M25 junction 10/A3 Wisley interchange TR010030 8.4 Statement of Common Ground with Historic England

8.4 STATEMENT OF COMMON GROUND WITH HISTORIC ENGLAND

STATEMENT OF COMMON GROUND

This Statement of Common Ground has been prepared and agreed by (1) Highways England Company Limited and (2) the Historic Buildings and Monuments Commission for England (Historic England).

100

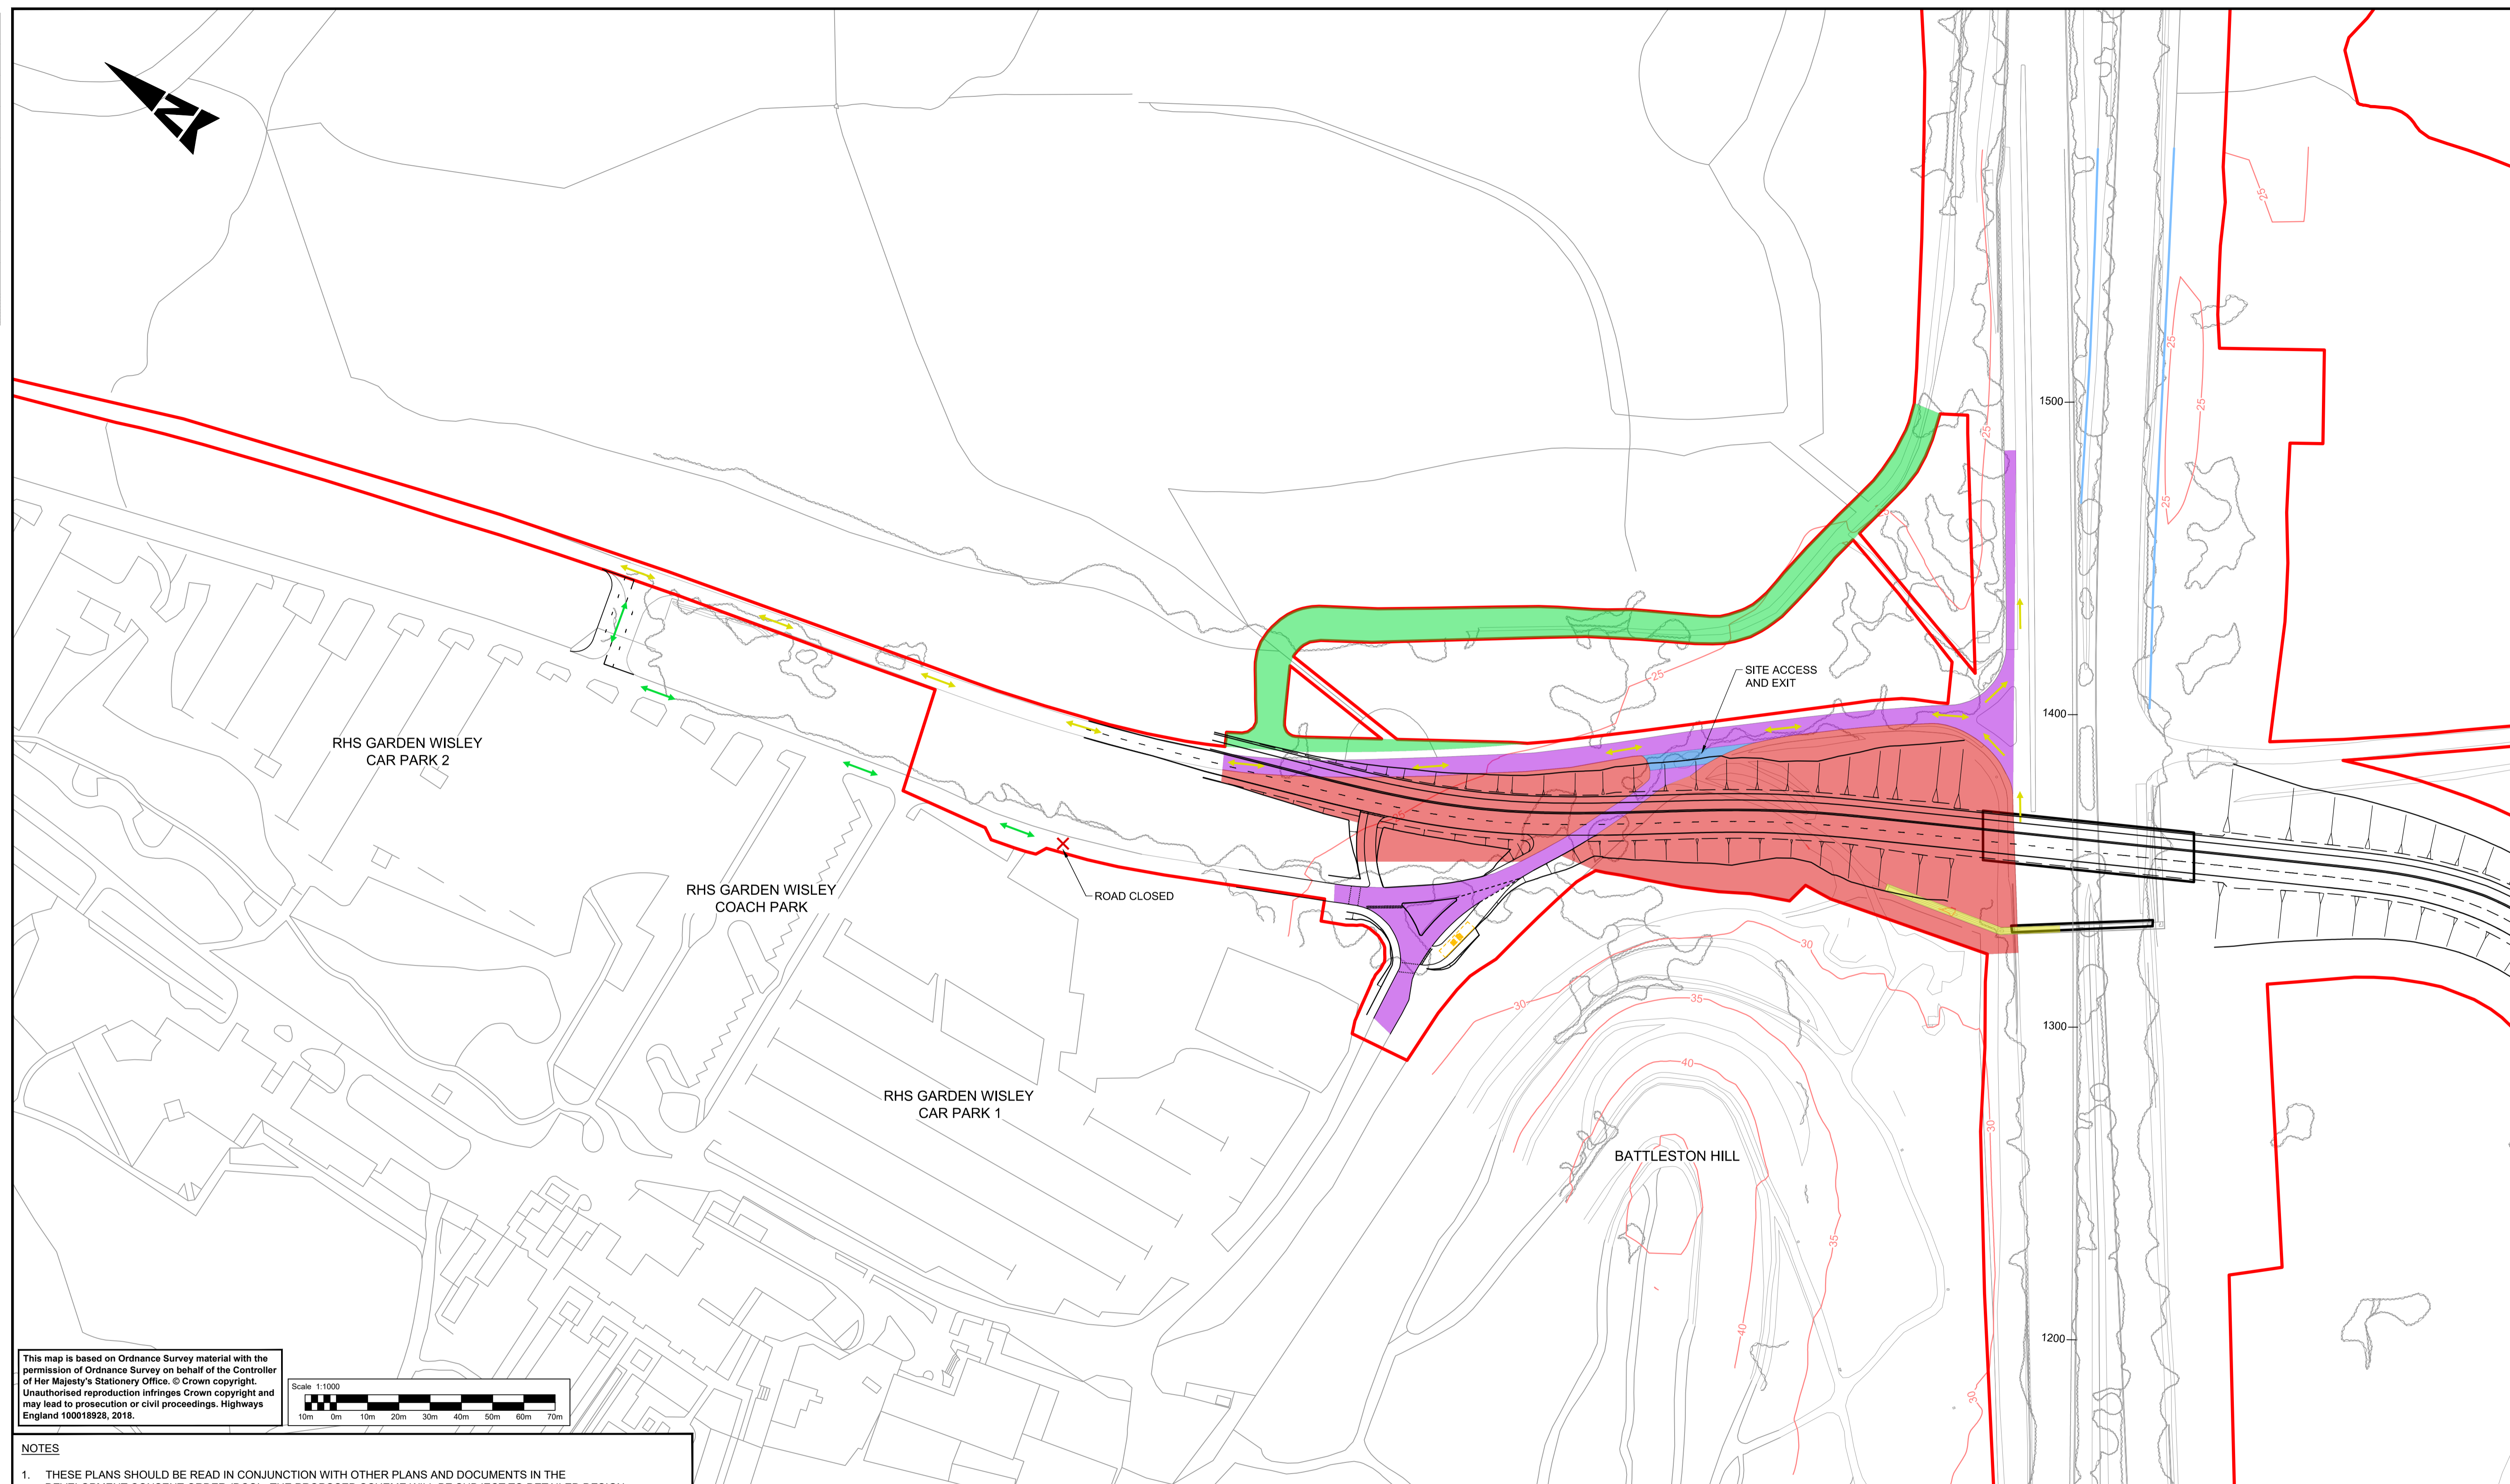
3.2.12	RHS Wisley	RHS Wisley; Scheme design	More detail is required on the design of construction within RHS Wisley at the north-east corner where the existing footbridge will be rebuilt as a road bridge. Historic England wants to consider this before agreeing what the effect on the significance of the heritage asset will be.	The Scheme design near RHS Wisley has been modified to address concerns raised by RHS Wisley and Historic England. In pre-Environmental Statement meetings.	Agreed
